Re: Objection to MP08_0244 MOD 1 Modification Request for Mixed Used Development at 23-37 Lindfield Avenue and 11 Havilah Lane, Lindfield

As a resident of Lindfield, I/we wish to lodge an objection against the proposed Modification of the subject development based on the following grounds:

DRAWING TITLE:
SHADOW DIAGRAMS - JUNE

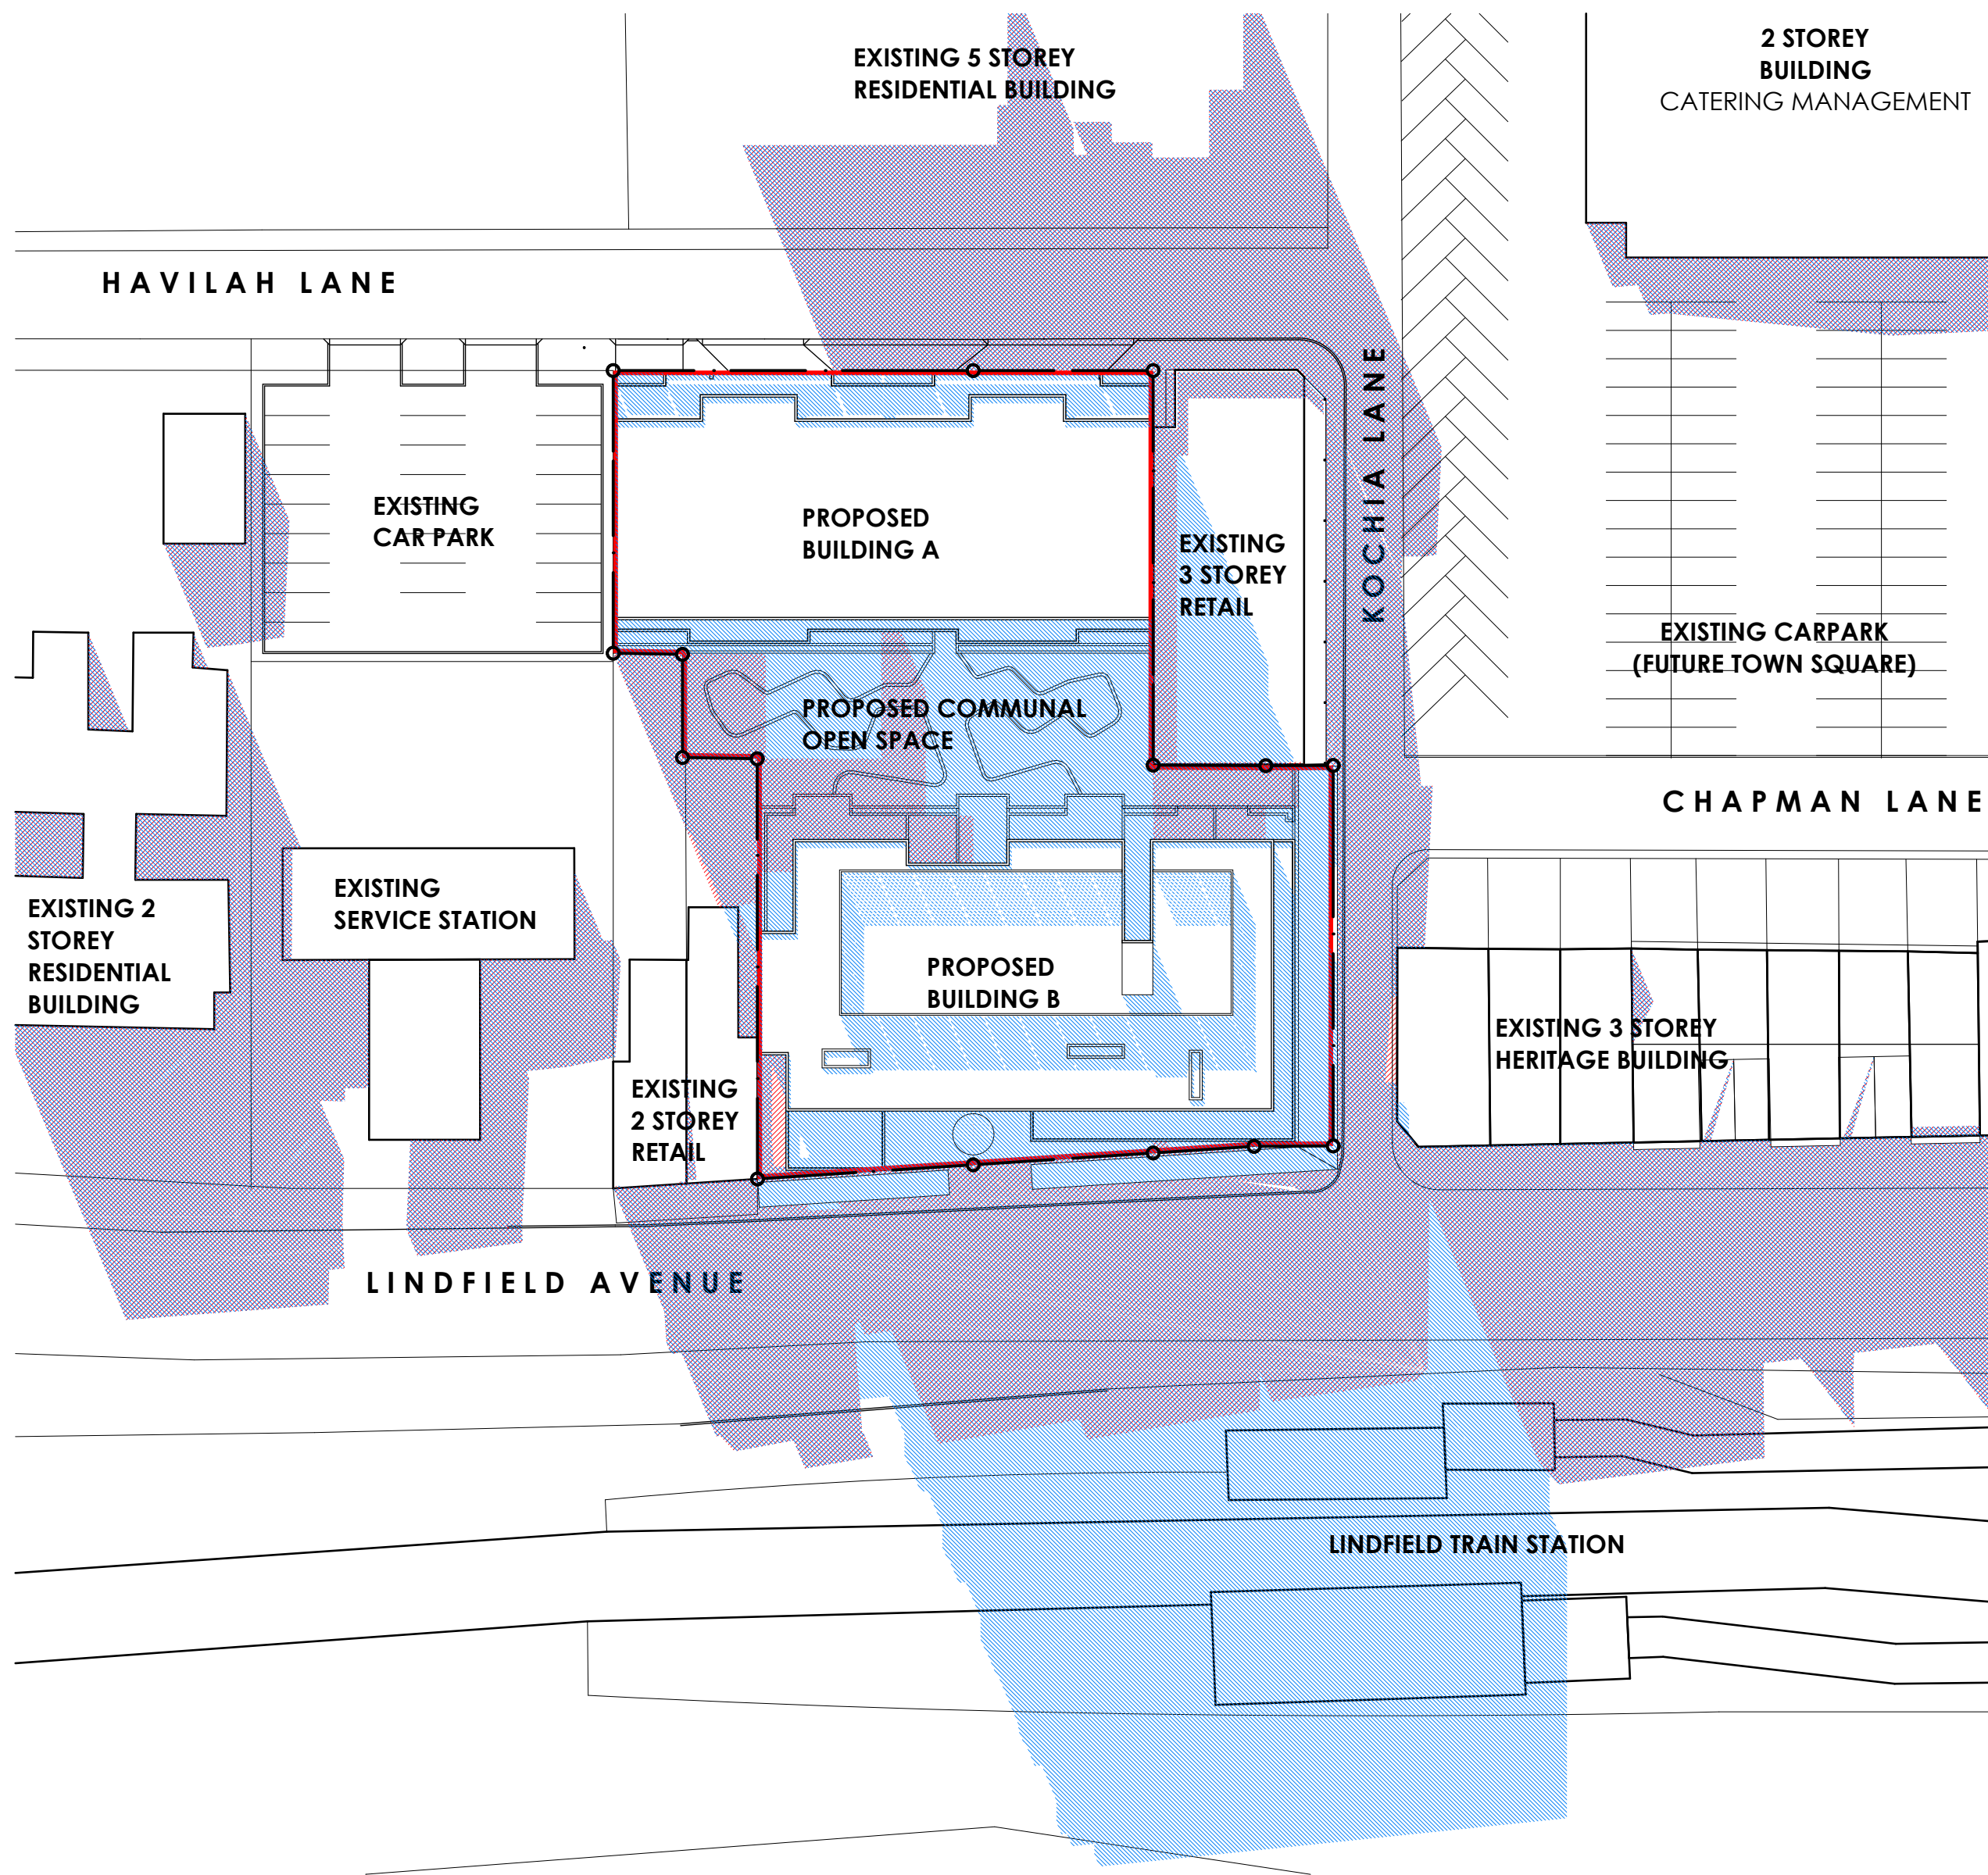
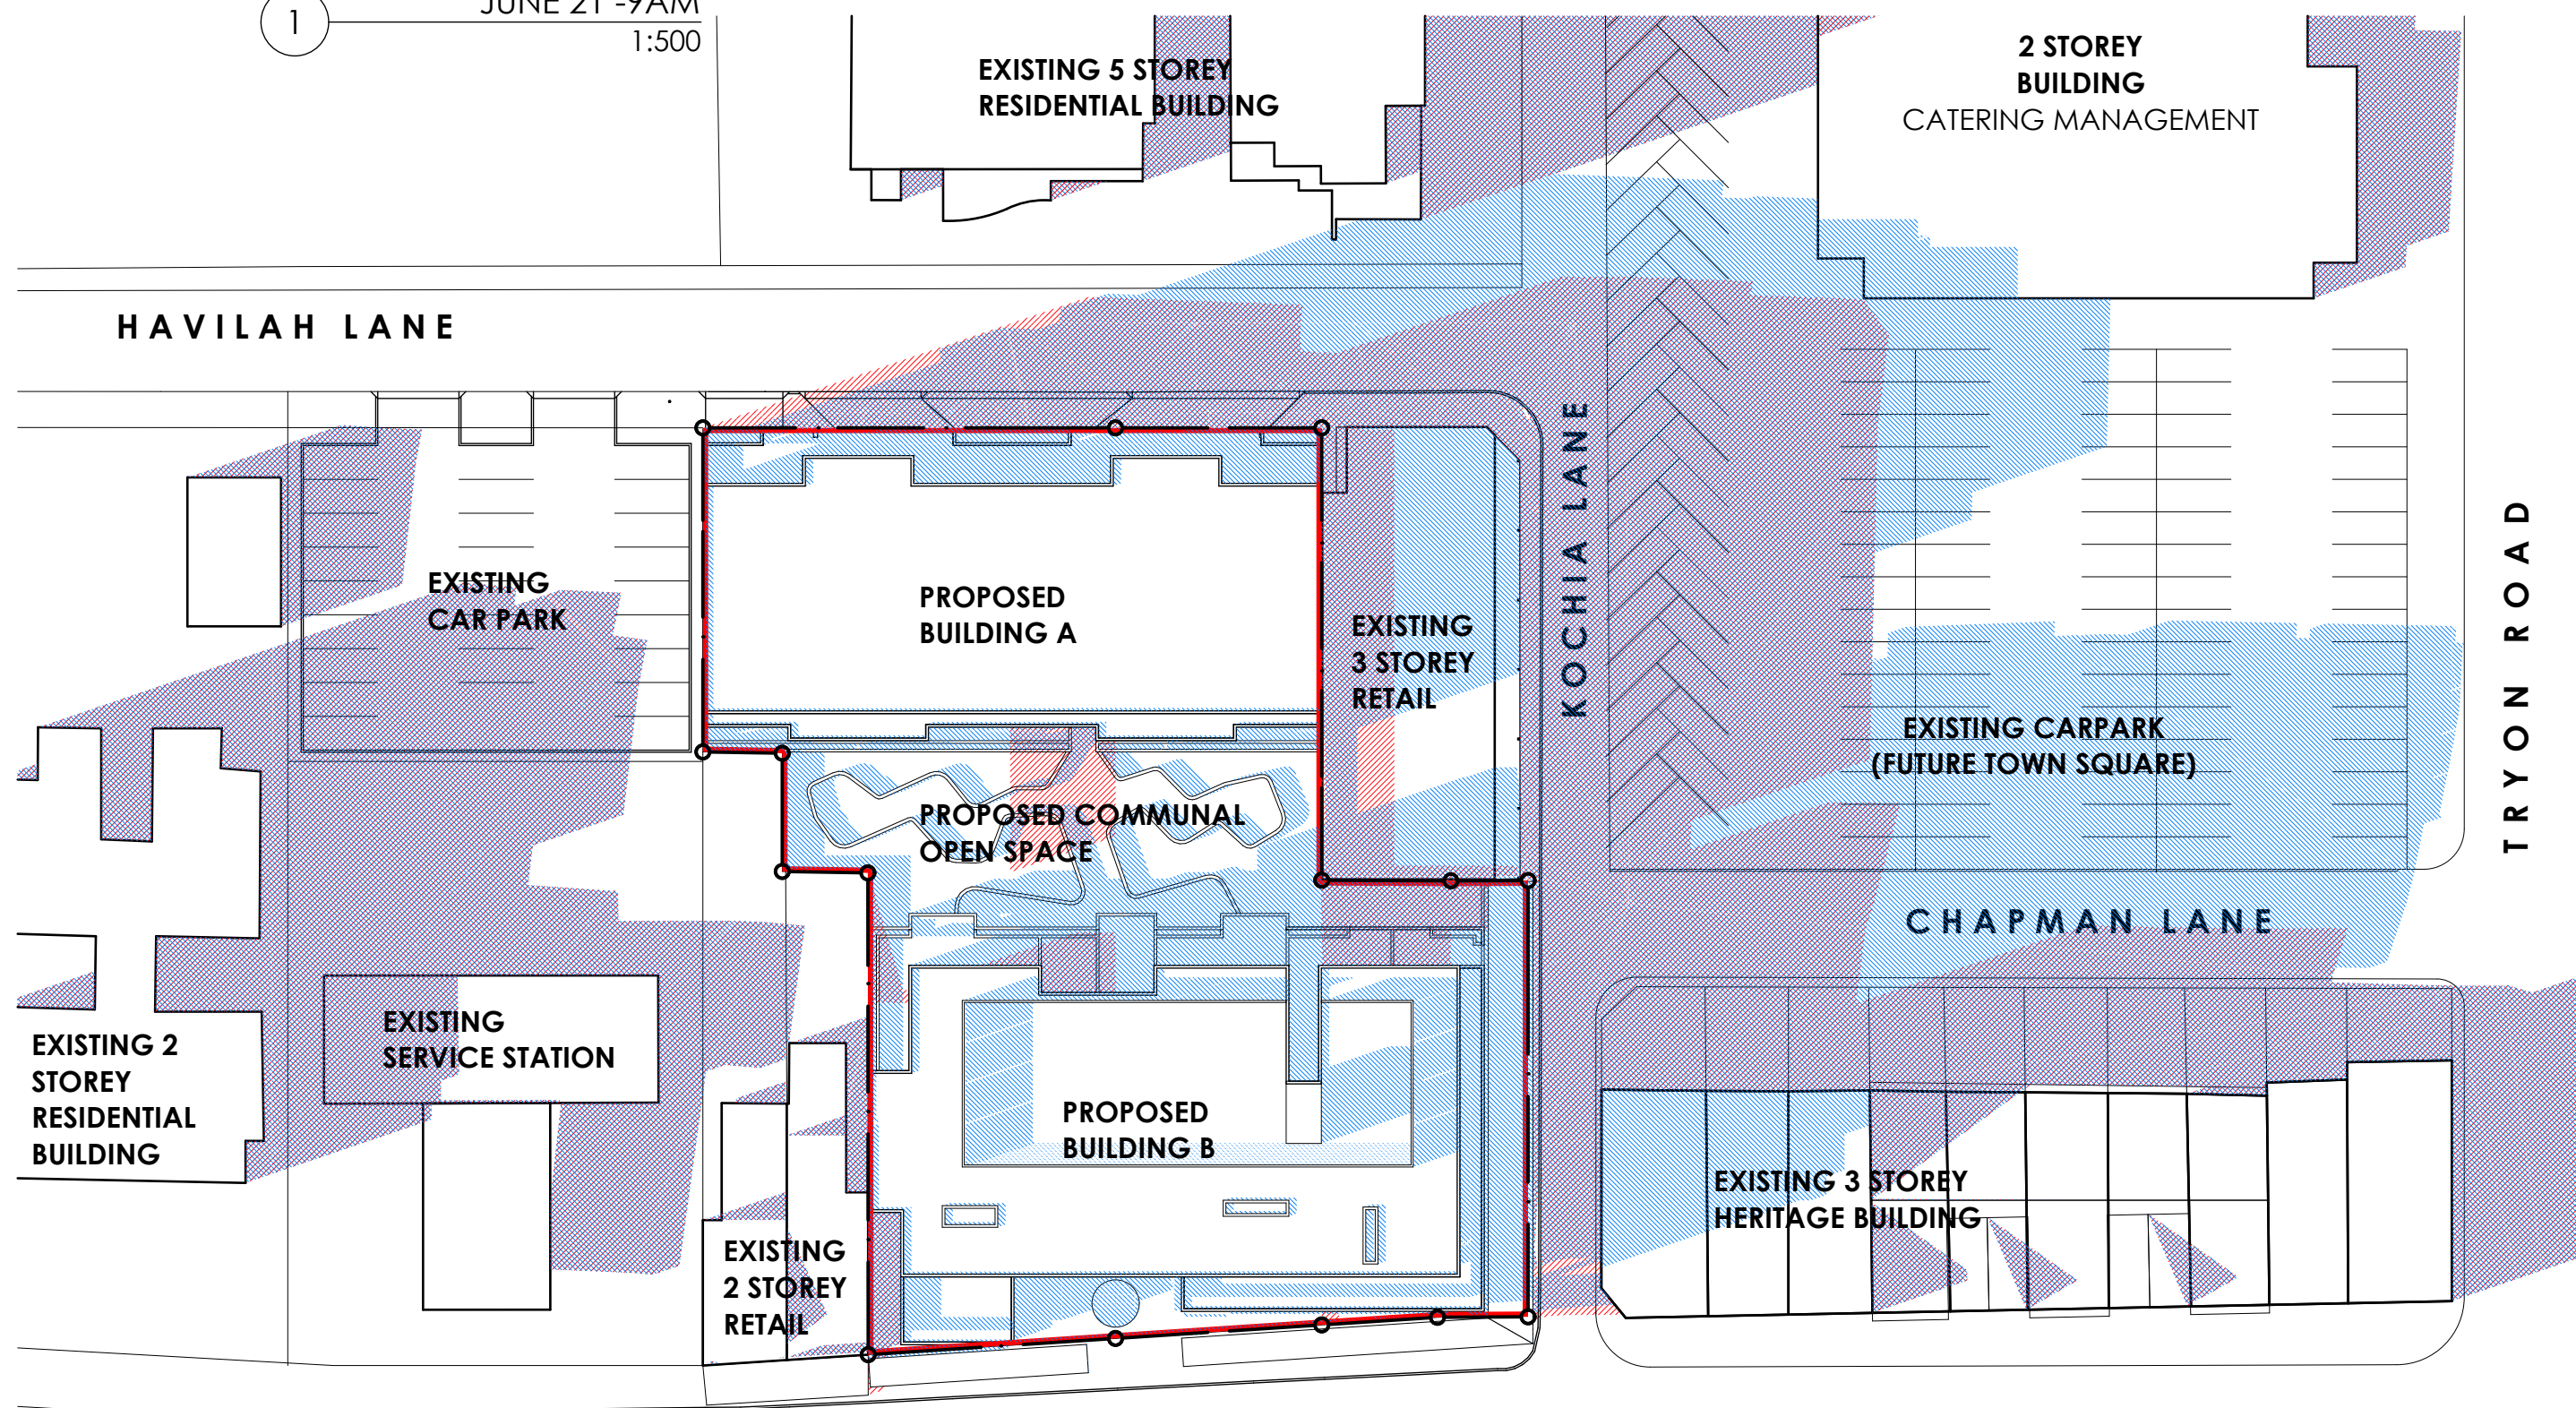
- The additional storeys create new adverse shadowing: a) for residents in the Havilah Lane apartments, particularly after 3pm b) for the popular outdoor café and central Lindfield hub area at 12 Tryon Road in afternoons, particularly in winter and c) for all commuters on the city bound Lindfield rail platform, instead of 50% of the year as approved, it will now be in shadow in the mornings 75% of the year
